**Moorebank Intermodal Precinct West - Stage 3 (SSD-10431)  
Response to Submissions**

Attachment 1: Supplementary Key Issues

## Supplementary Key Issues

PLAN OF SUBDIVISION OF LOT 1 IN DP1197707 AND LOT 100 DP1049508

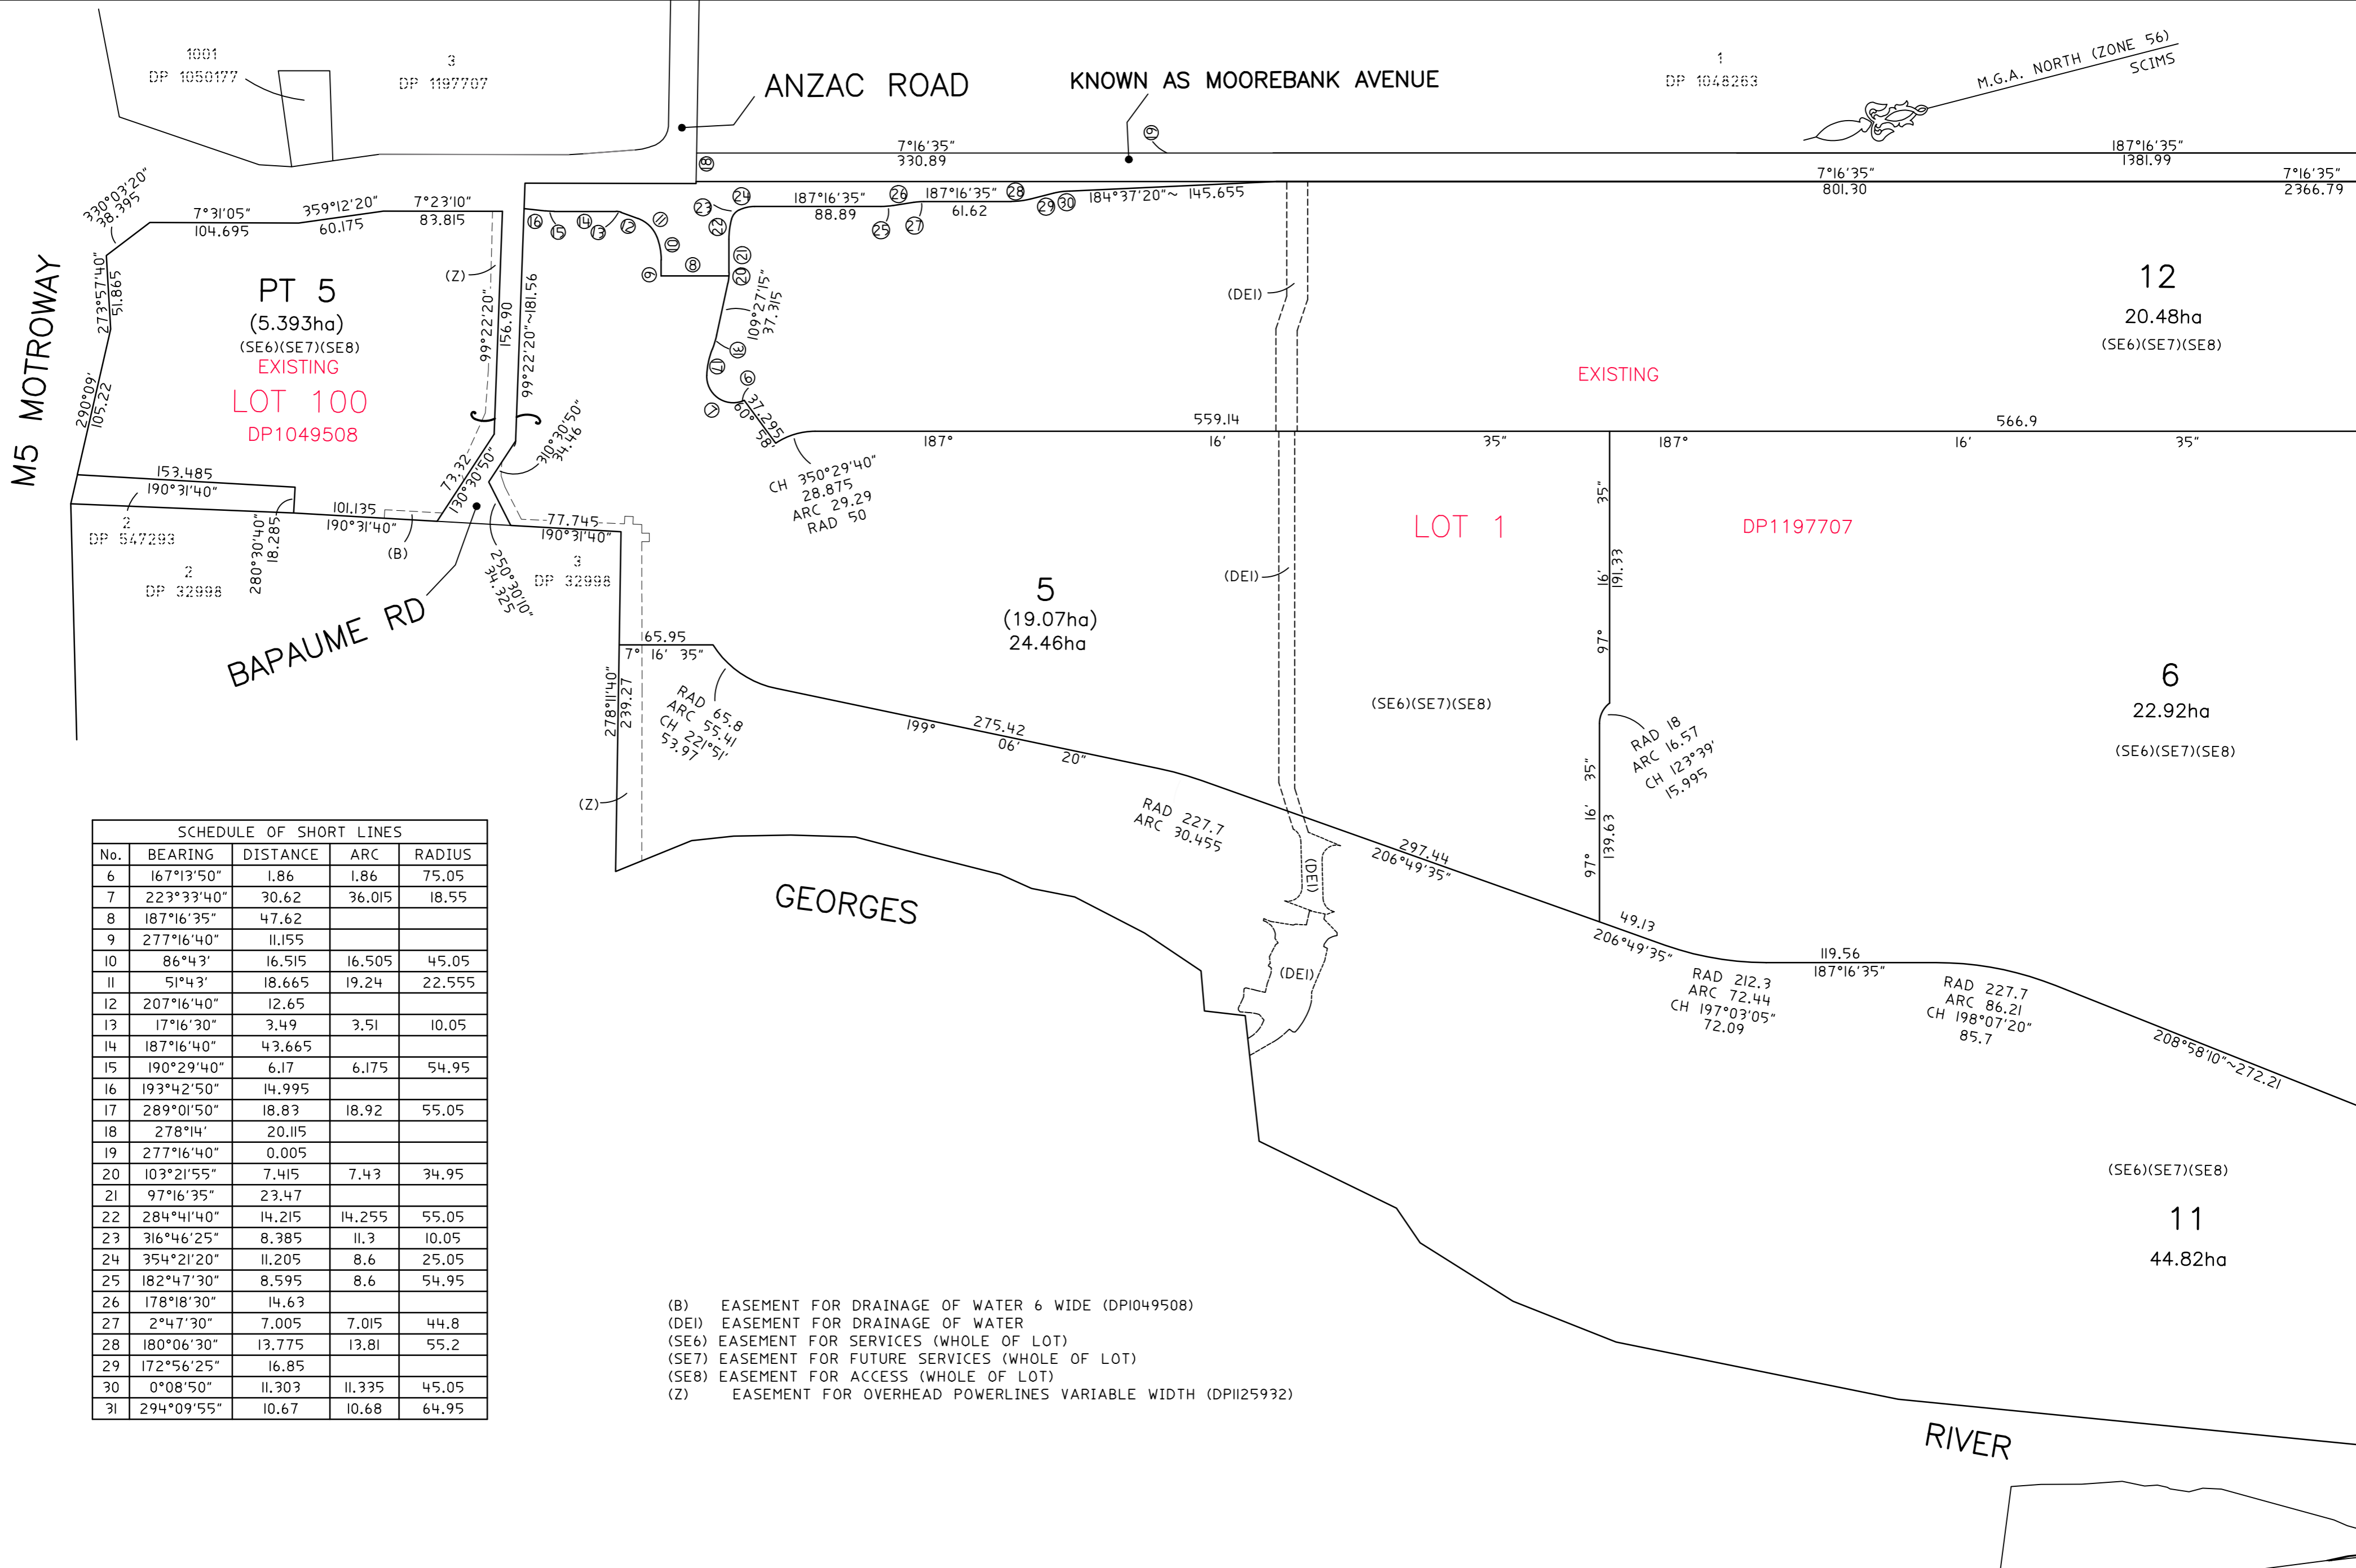
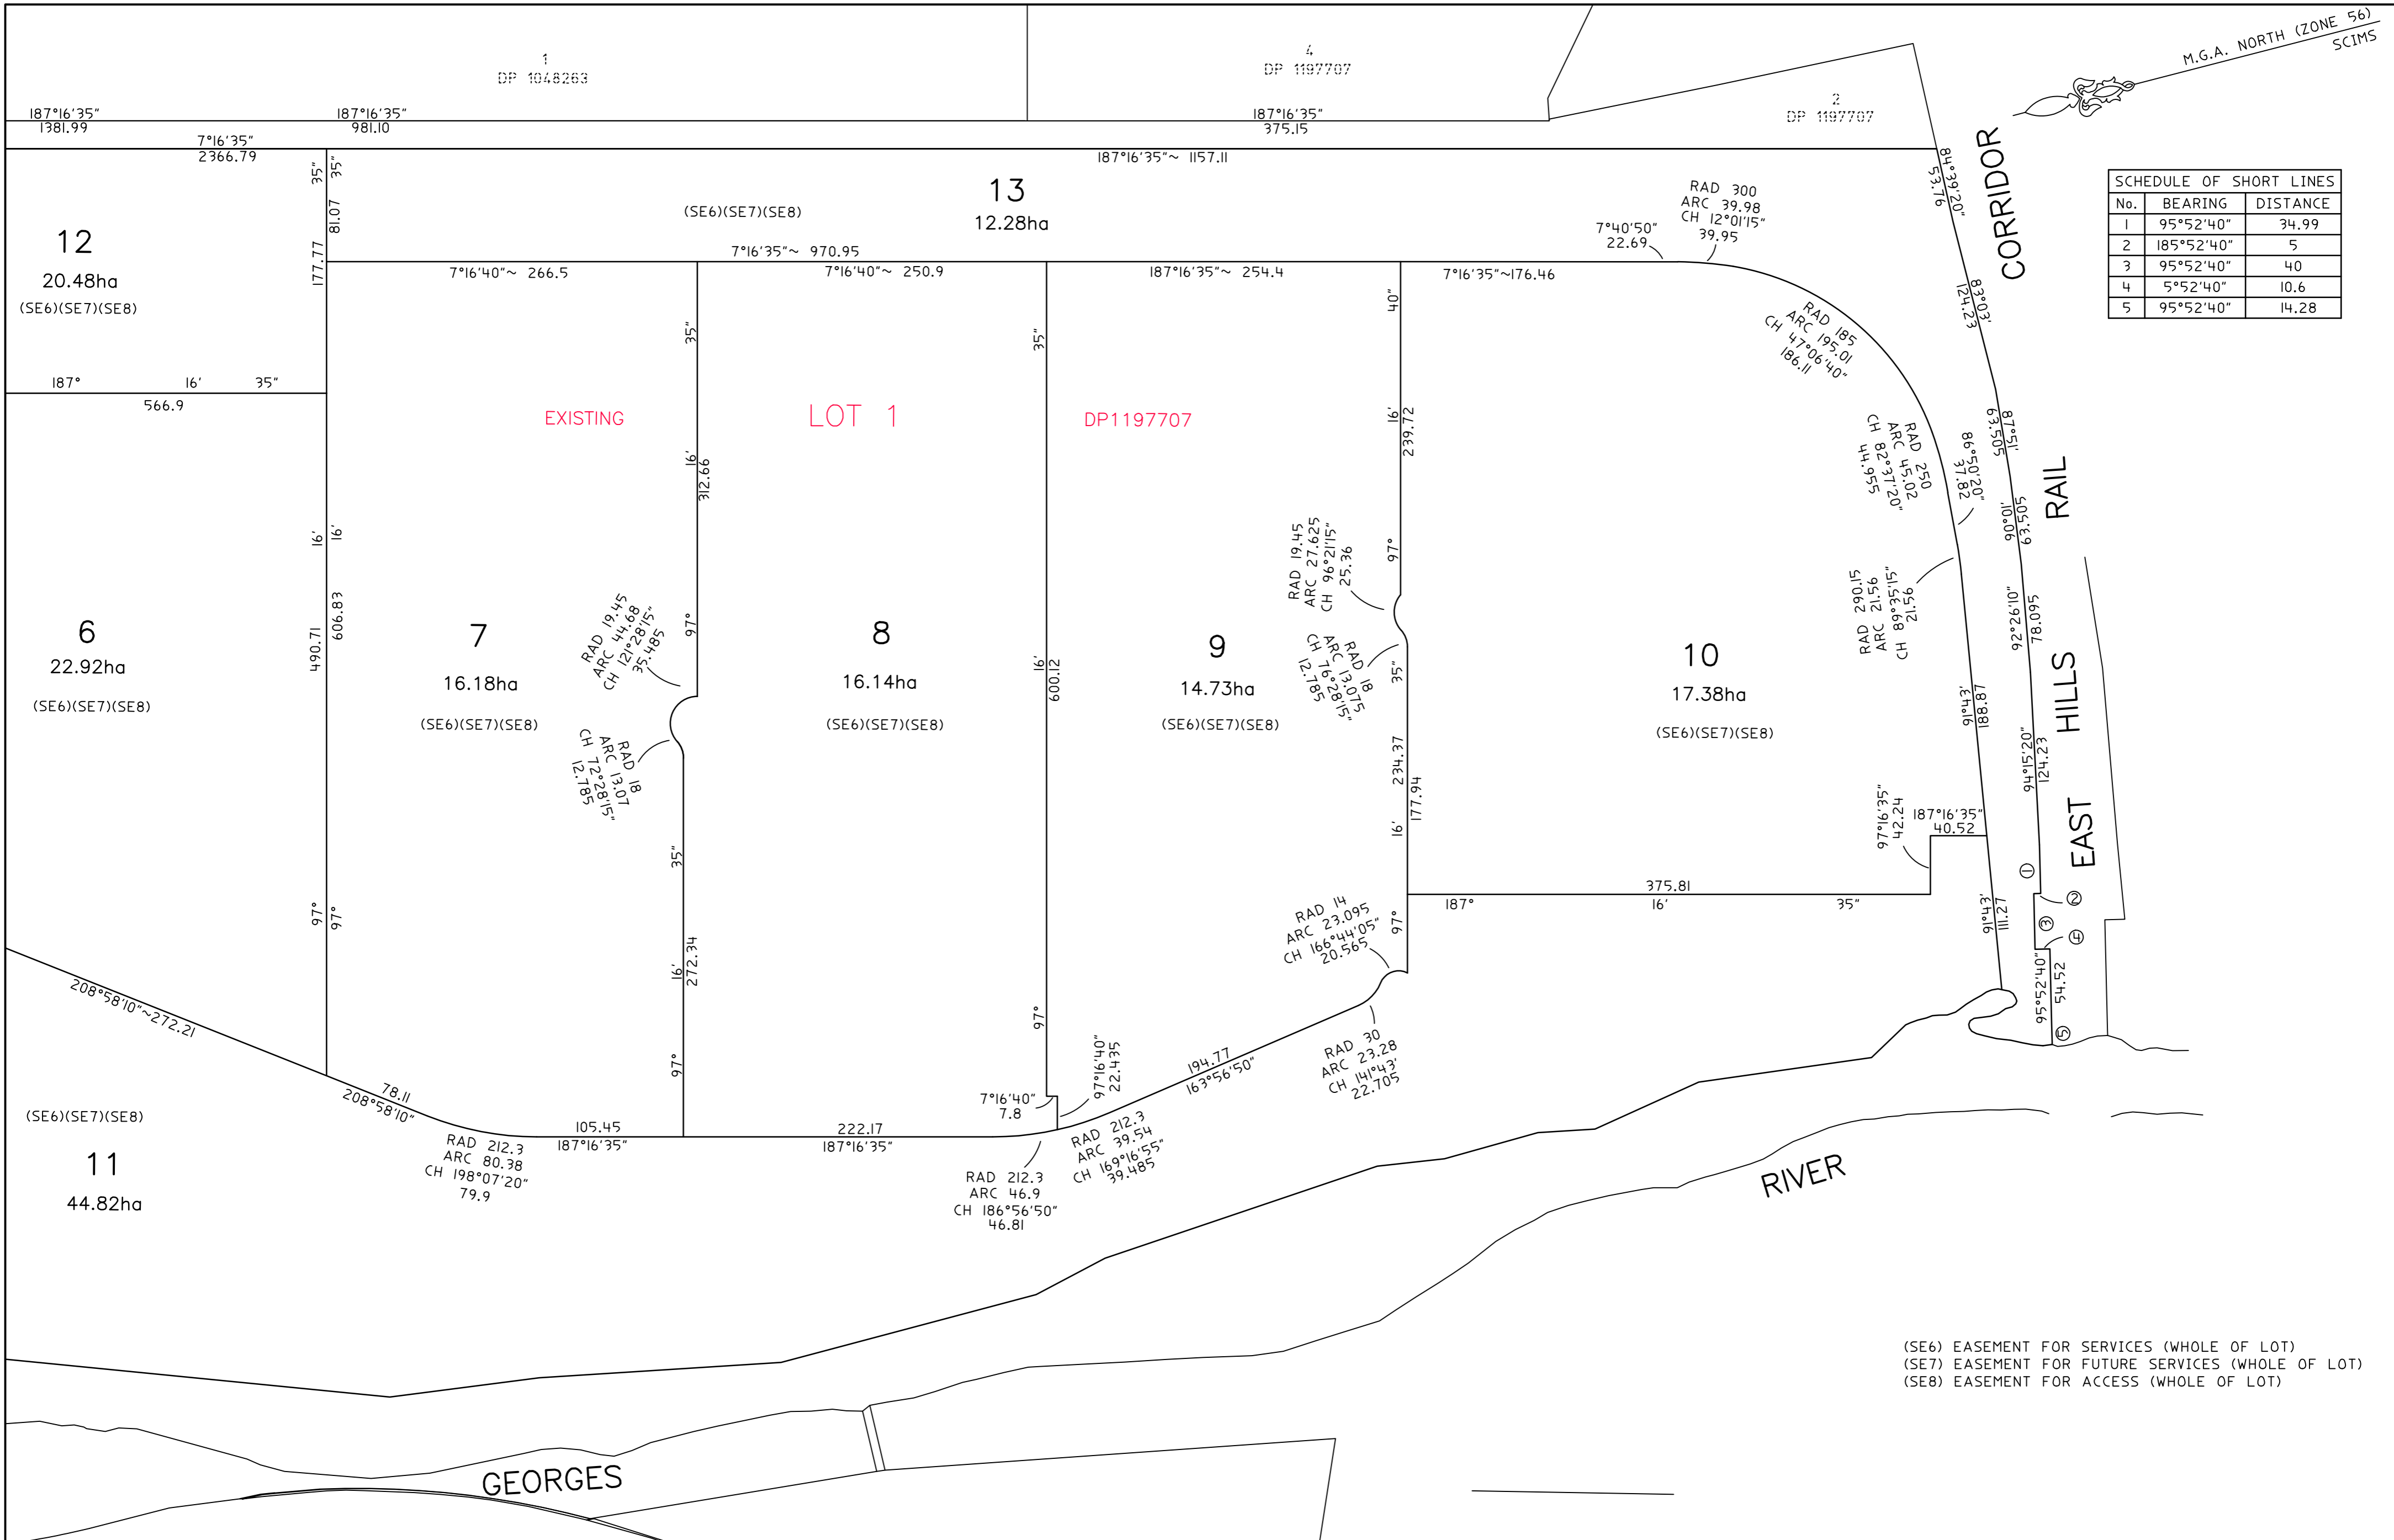
Further information is required to support the Applicant's 'Clause 4.6 Request – Minimum Lot Size Requirements' (Appendix F of the EIS) and subdivision plans provided as part of the EIS.

In particular, the Submissions Report must provide a detailed response demonstrating how objective (c) in clause 4.1 (1) of the LLEP would be achieved, including the mechanisms proposed to prevent fragmentation of the MPW site. This includes demonstrating how the construction, operation and management of the MPW site would allow for the development of a 'holistic intermodal freight terminal', rather than an industrial park or estate.

The Department requests that further information is provided to demonstrate compliance with the requirements of condition E26 of Schedule 4 (Conditions to be met in future development applications) of SSD 5066 (as modified). In particular, the Submissions Report must address the requirements of condition E26 (c) in detail and provide an updated set of subdivision plans that clearly illustrate completed estate works for the entire MPW site, including maintenance of access roads, pedestrian paths, landscaping, lighting of common area and provision for emergency services including for firefighting. If this information has been submitted to the Department as part of an Urban Development Design Report (UDDR) for MPW Stage 2 works (northern portion of the MPW site), then that information must also be provided as part of the Response to Submissions Report. This information is also required for the proposed works compound in the southern portion of the MPW site.
